A R C H I T E C T Y P E

Sheridan Street Townhouses

Addendum 2

1 detail
1 1/2" = 1'-0"

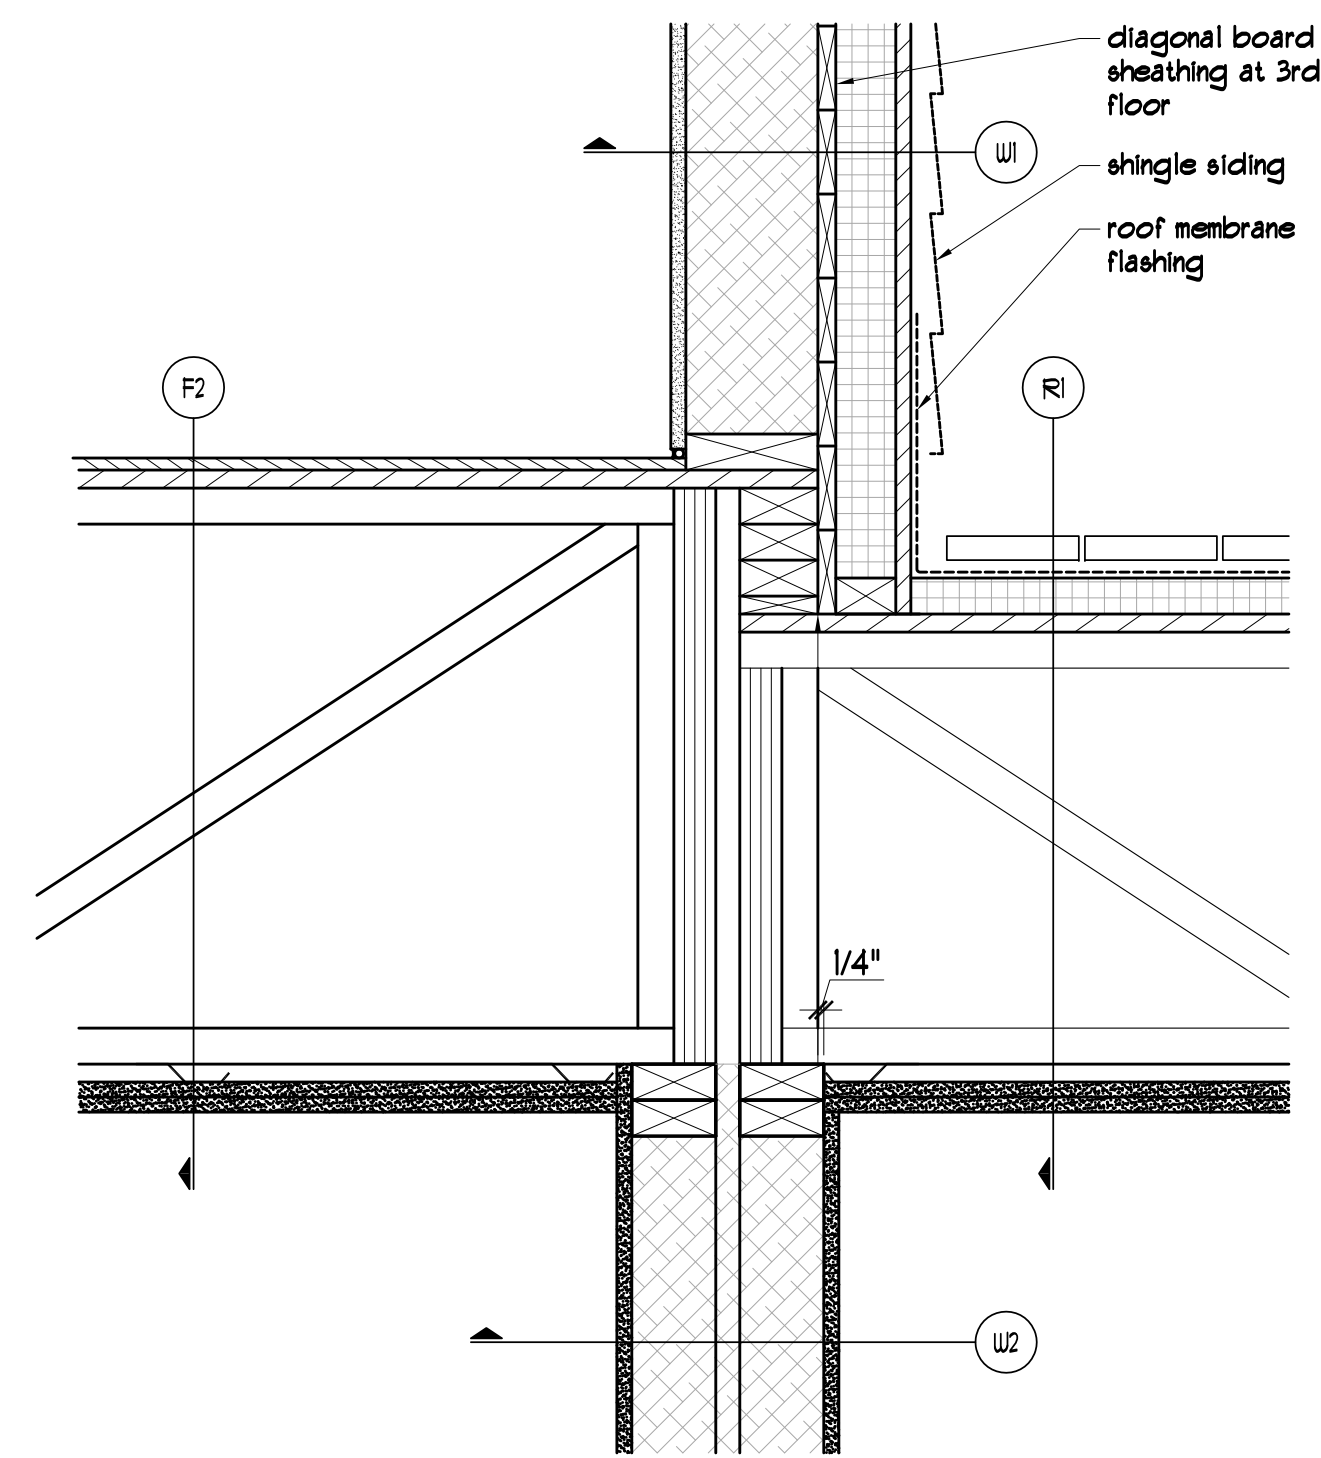
Item 9: Sheet a2.1: Detail tag at top of bay above entry porch shall refer to detail 1, sheet a5.1
